YorkshireWater

**Your Ref: 2026/0040
Our Ref: B/00060**

Schwabisch Gmund Way, Barnsley - (BARN) Variation of conditions 2 (Approved Drawing Schedule), 3 (Street Furniture and Signage Details), 5 (Parkour Area Details), 7 (Boundary Treatments), and 10 (Hard and Soft Landscaping) of planning application 2024/0475: Application for reserved matters relating to details pertaining layout, appearance, landscaping and scale of proposed activity park and associated buildings and infrastructure (relating to outline planning application 2022/0434)

Detail 1. Typical tree planting  
1:20

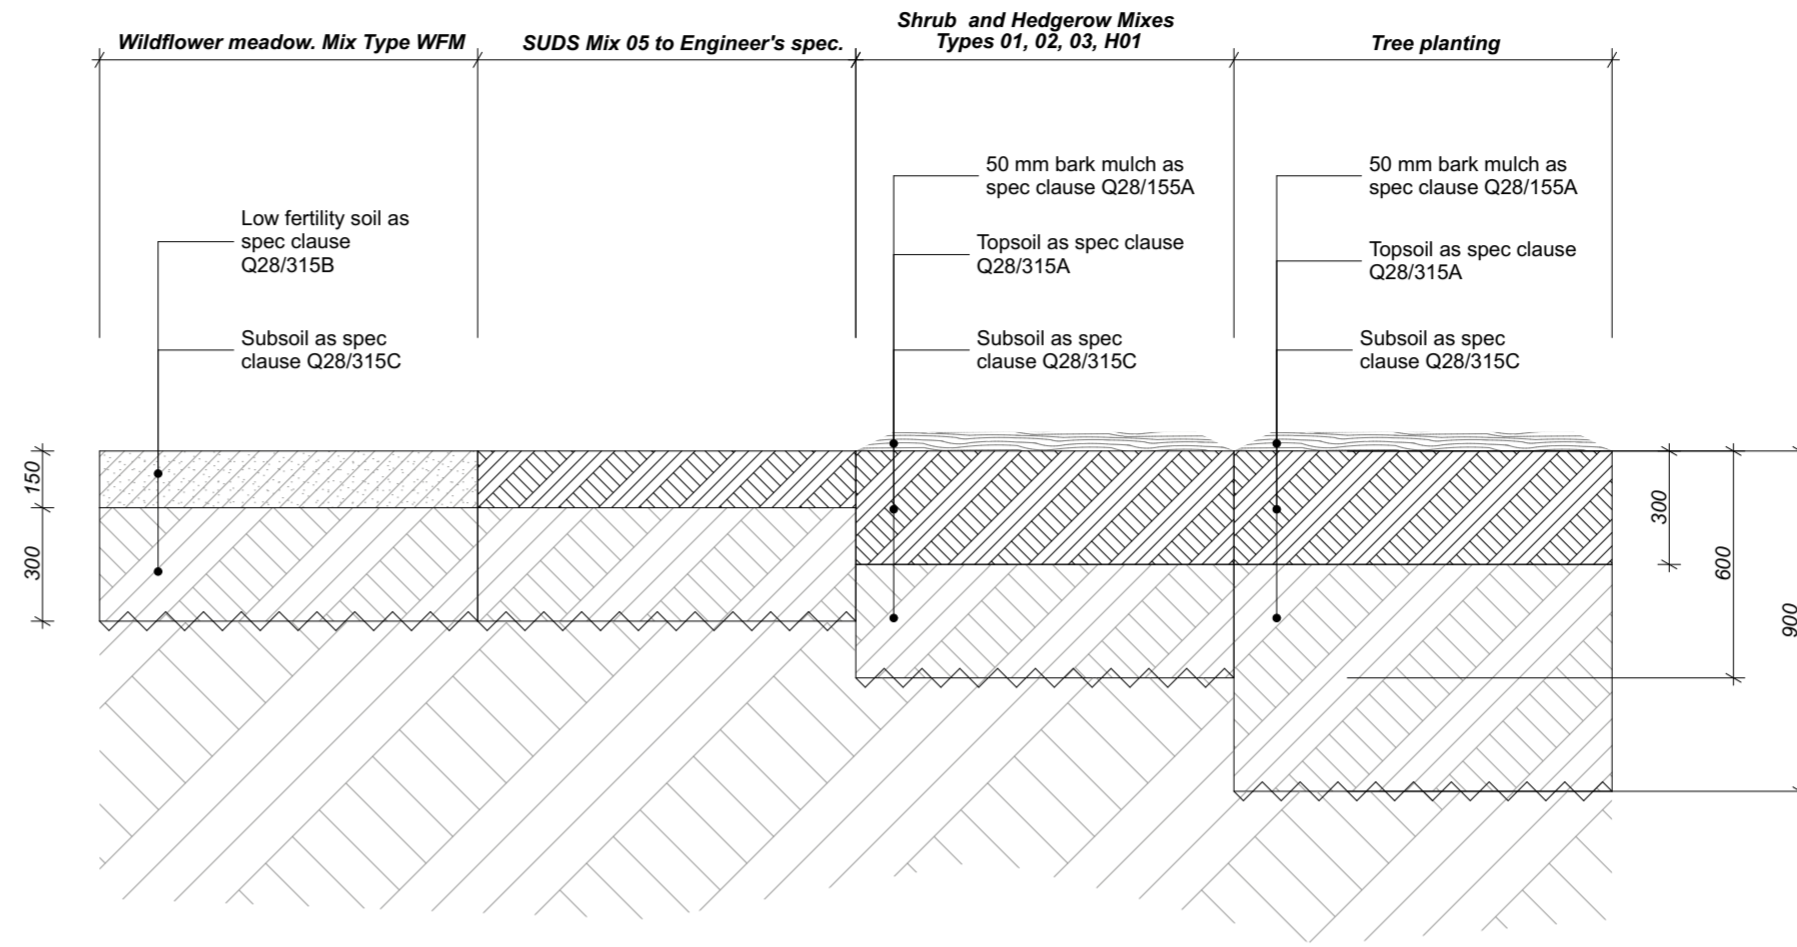
- c.) There should be no new tree planting within 5 metres of the public sewer network
- d.) In this instance, it would appear that the public sewer is unlikely to be affected by building-over proposals, or landscaping proposals.
